WEST SUSSEX COUNTY COUNCIL CONSULTATION

TO:	Arun District Council FAO: Anita Gardner
FROM:	Stephen Gee, Highways, WSCC
DATE:	14/02/19
LOCATION:	Land south of the A259, Grevatt's Lane, Climping, BN17 5RE
SUBJECT:	CM/4/19/PL Construction of a crematorium comprising of a crematorium building & associated structures, car parking, access & landscaped spaces. This application is a Departure from the Development Plan.
DATE OF SITE VISIT:	11/02/2019
RECOMMENDATION:	☐ Advice ☒ Objection ☐ Modification ☐ No Objection ☒ More Information ☐ Refusal
S106 CONTRIBUTION TOTAL:	£ See below for breakdown.

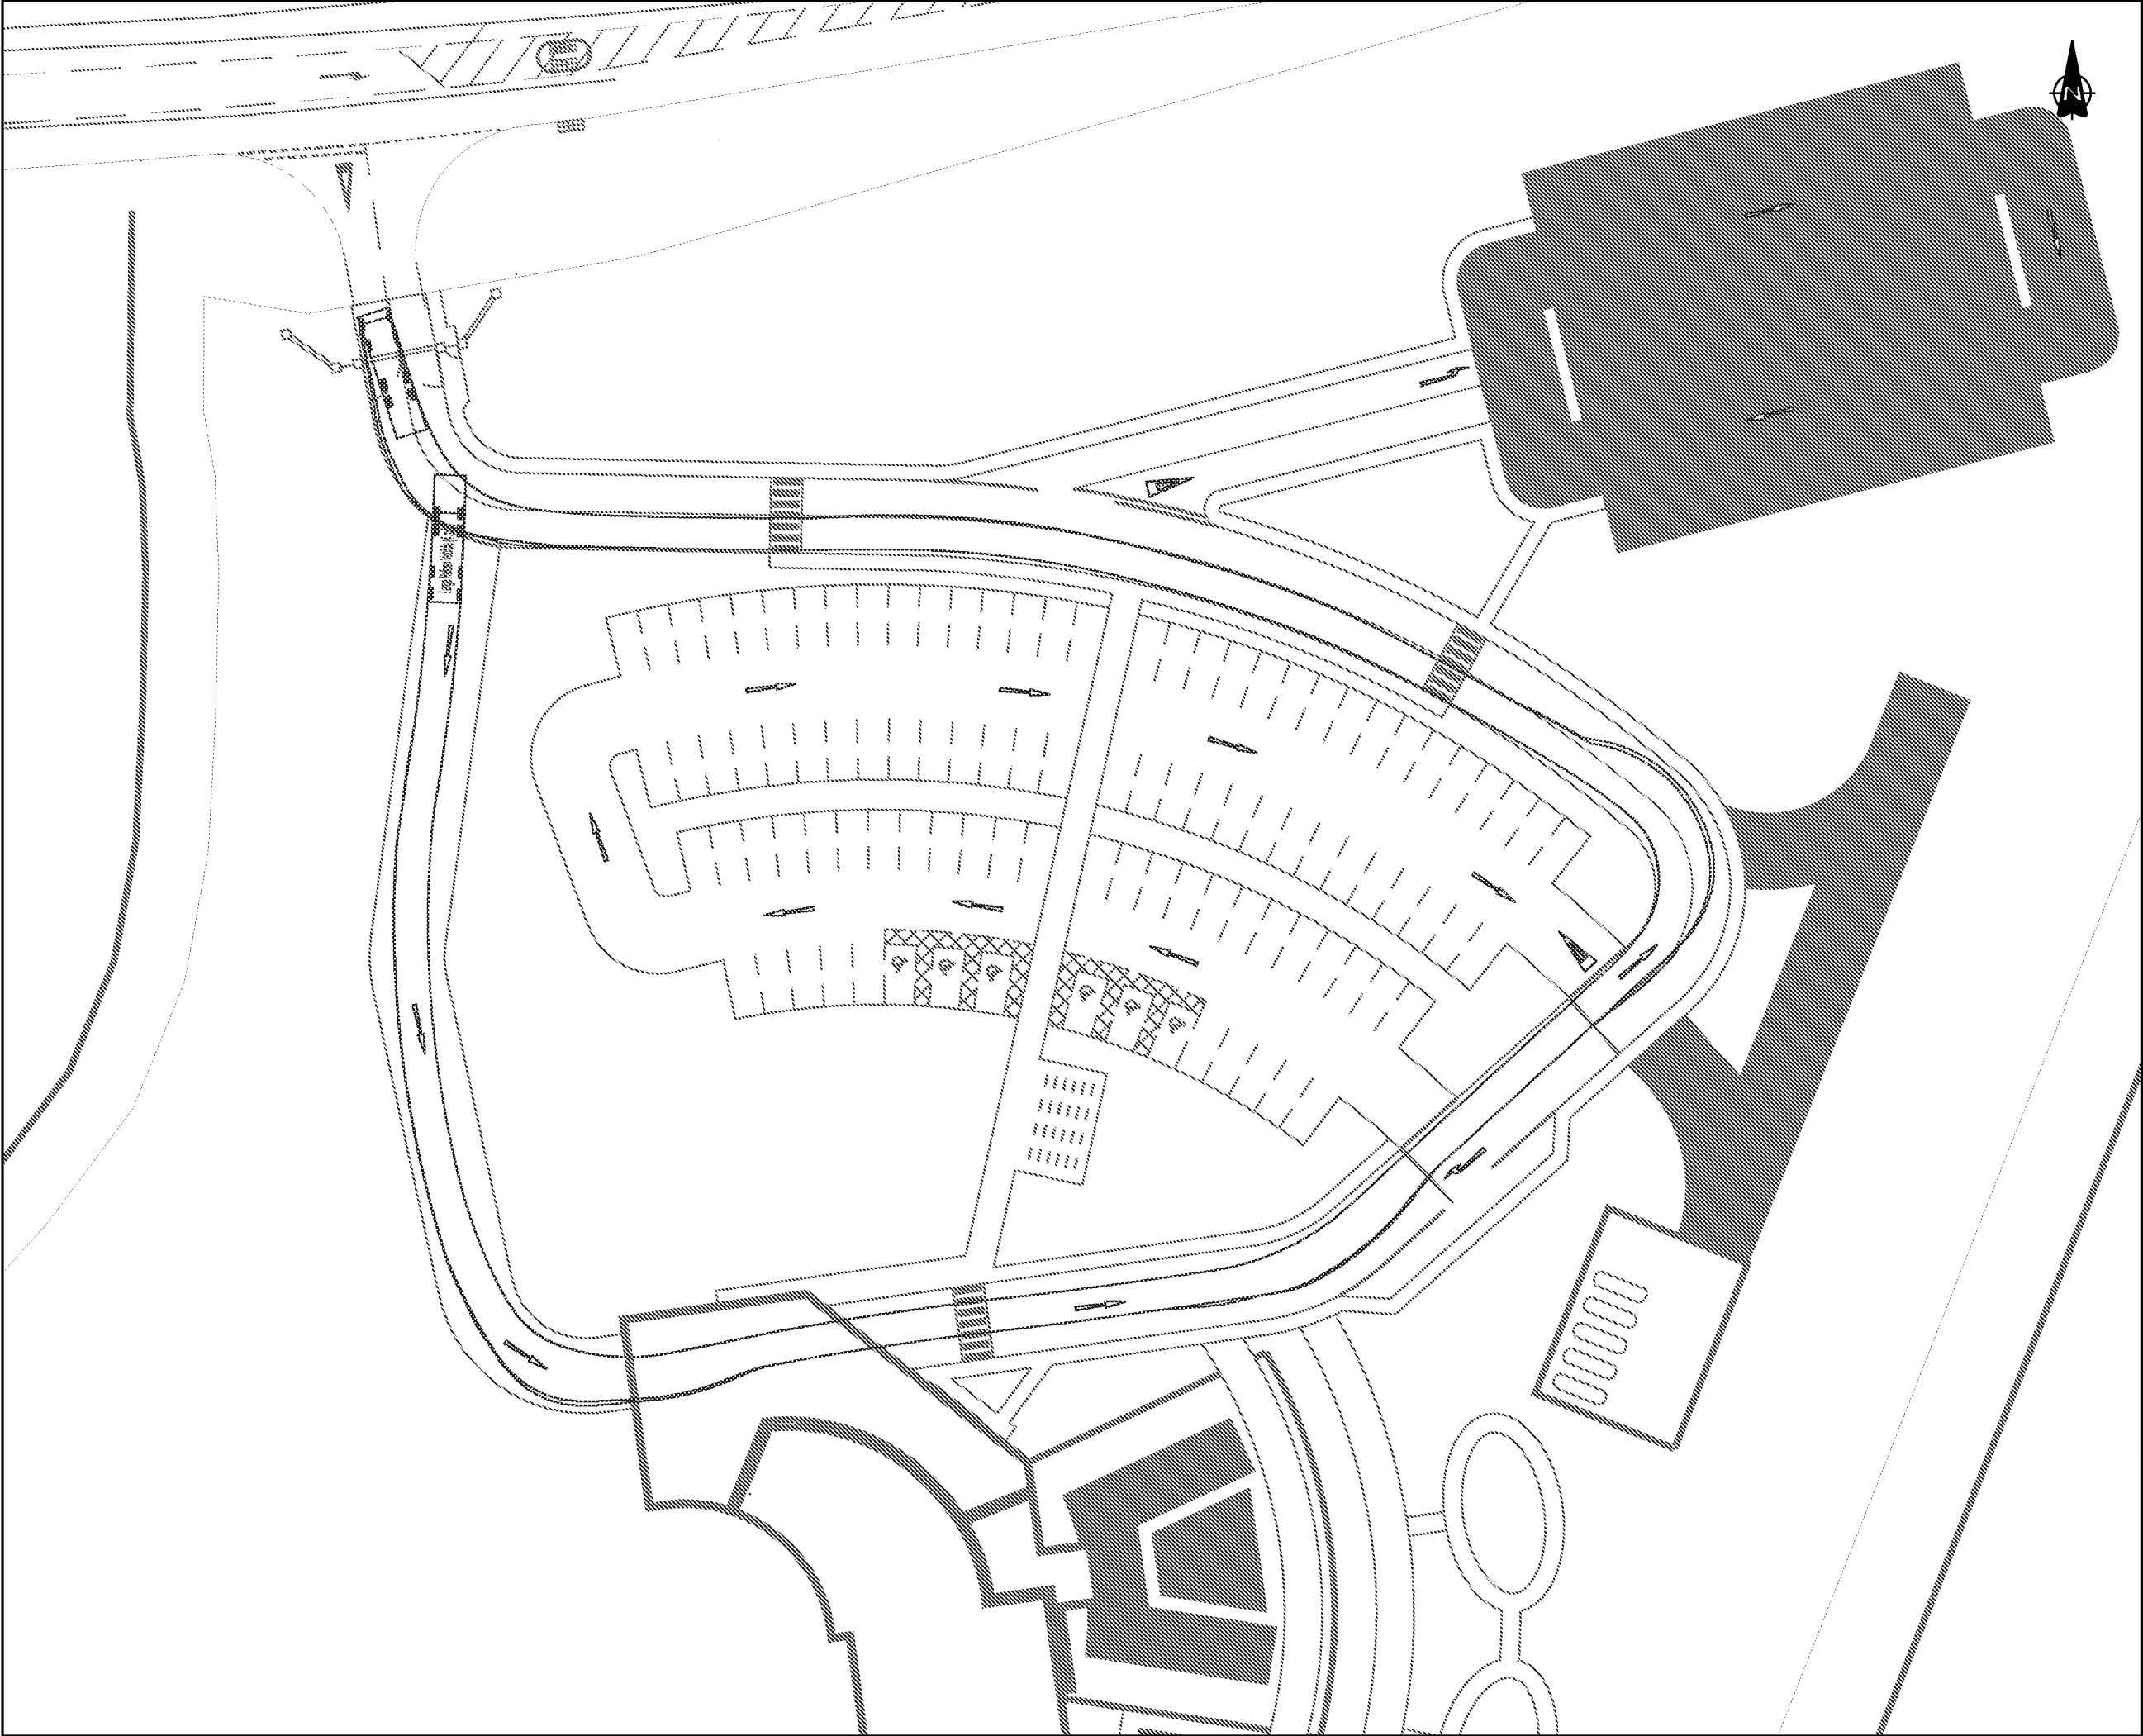
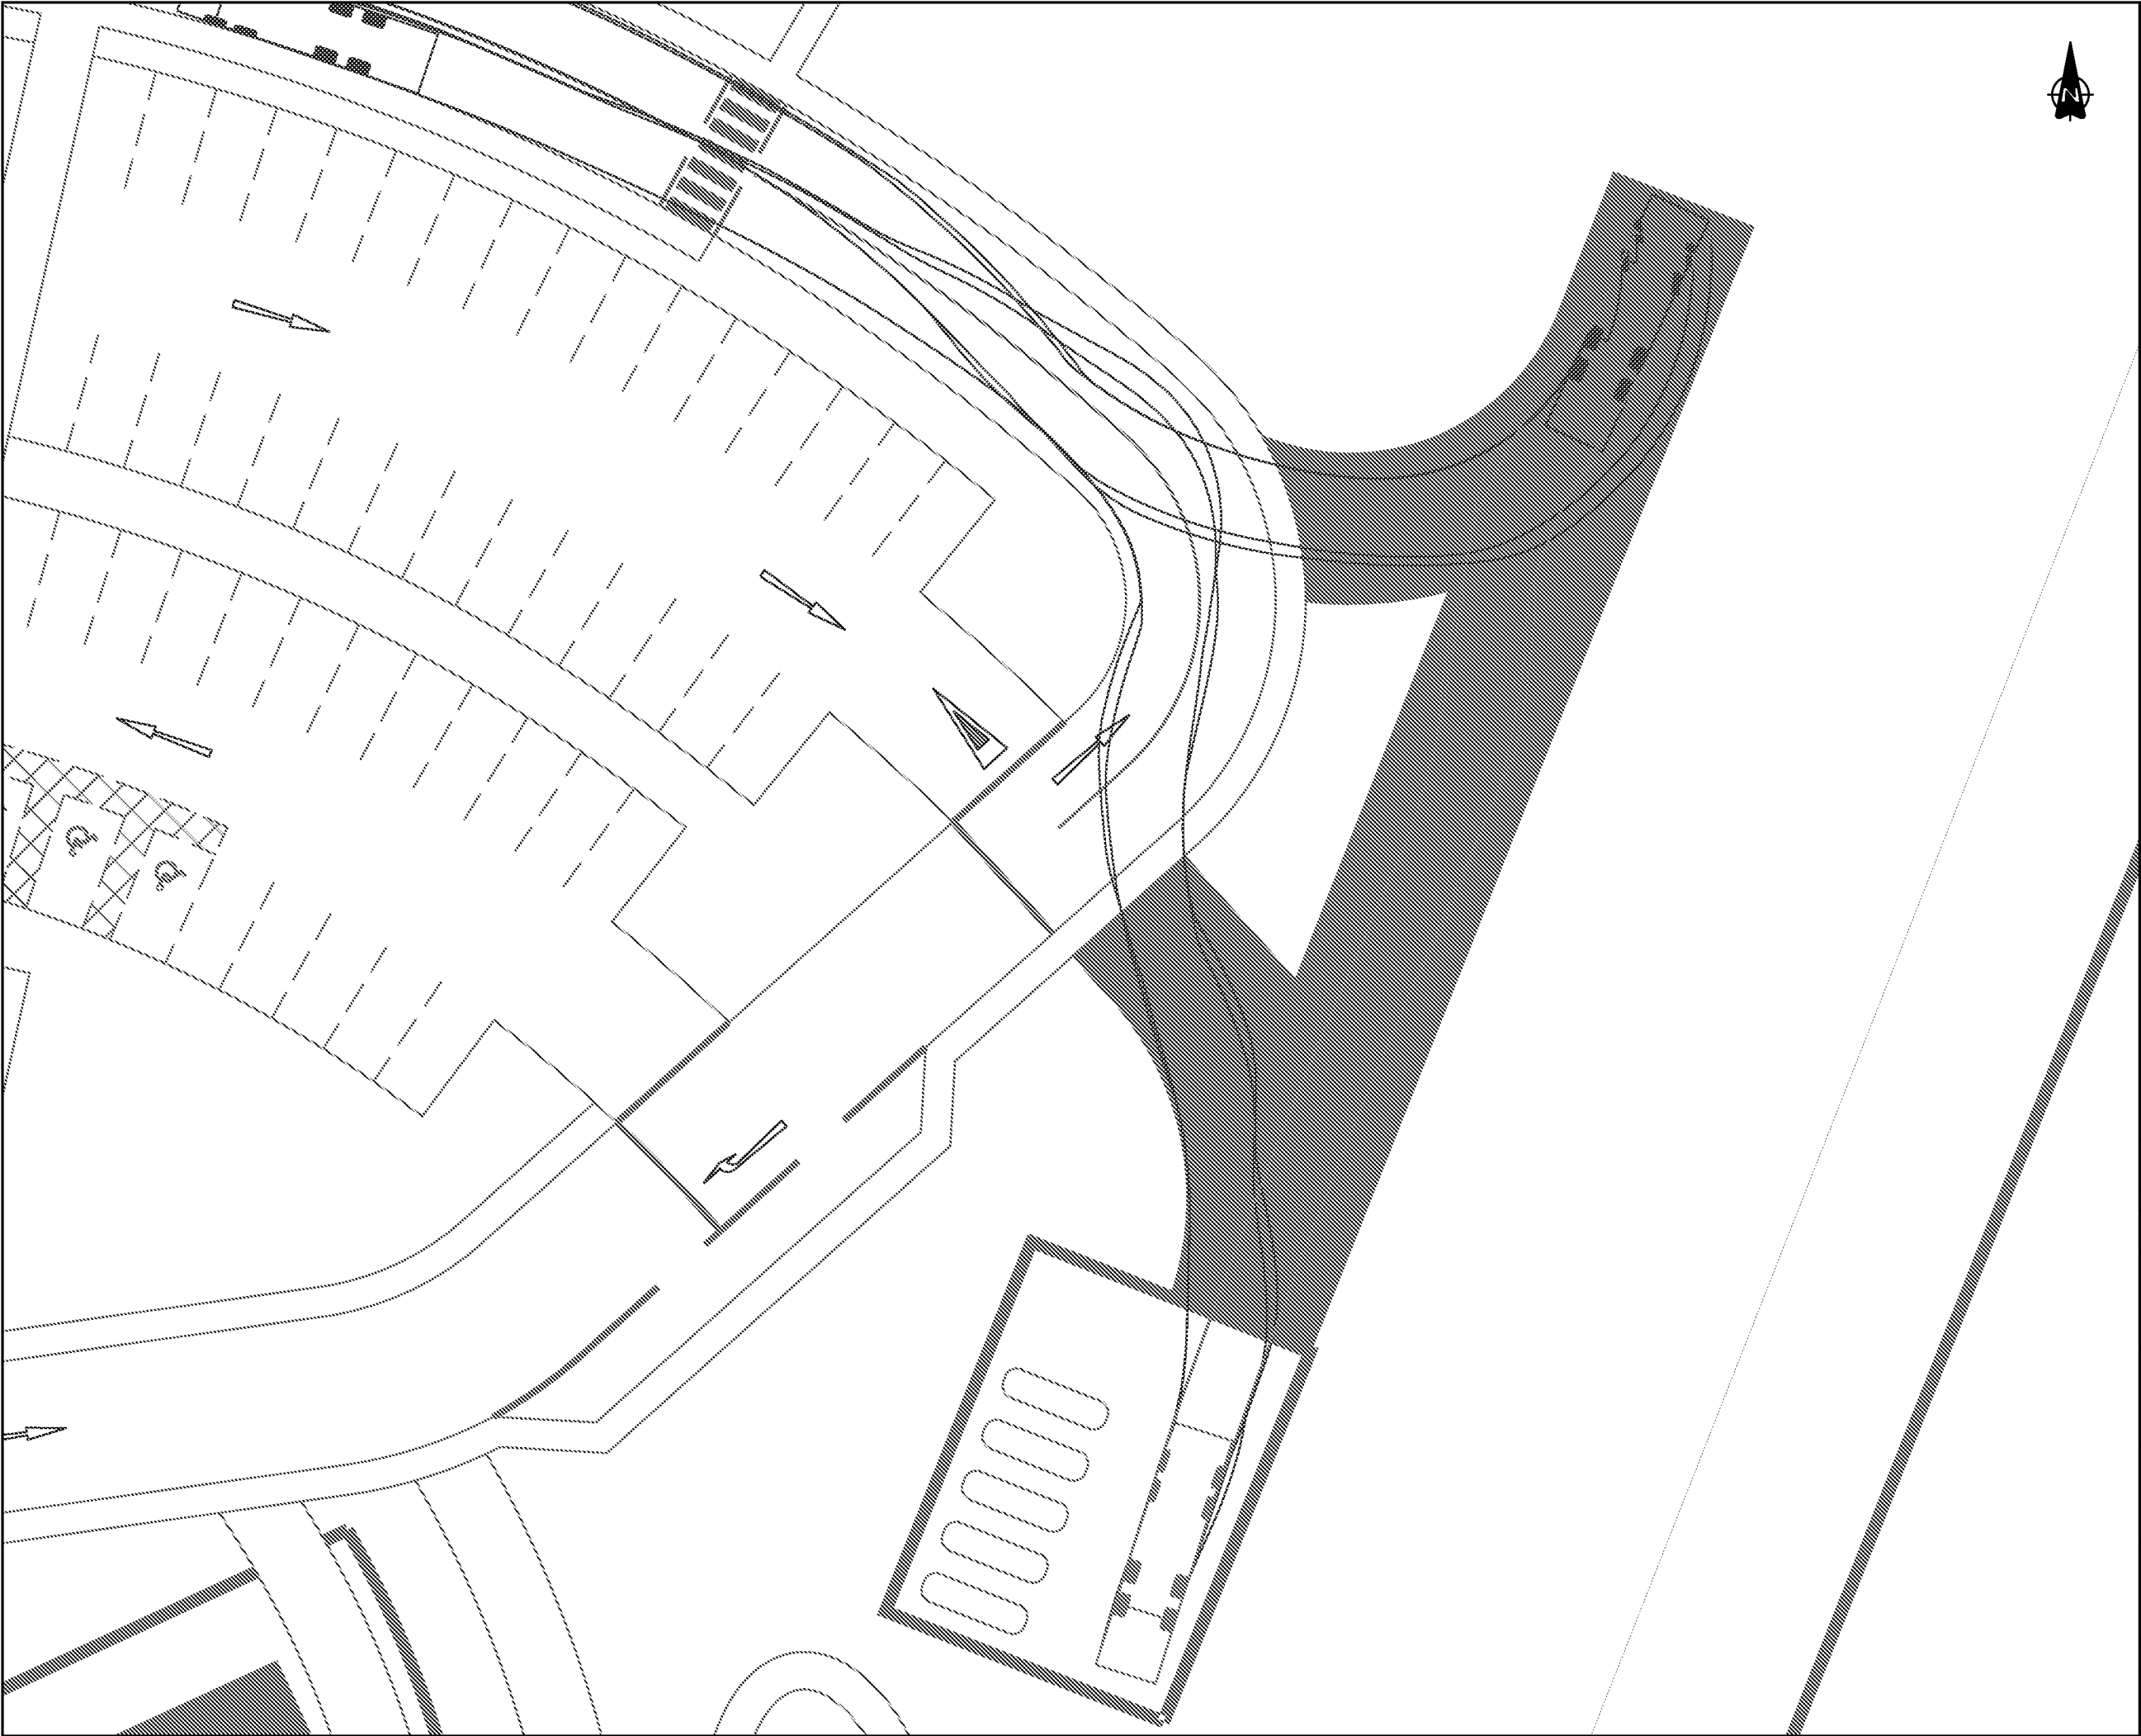
Vehicle tracking for a refuse vehicle has been provided and are accepted. It is noted that the site layout (appendix A) includes two areas marked no 5 – Service yard. Clarification is required to the requirement of a service vehicle accessing the southern numbered block.
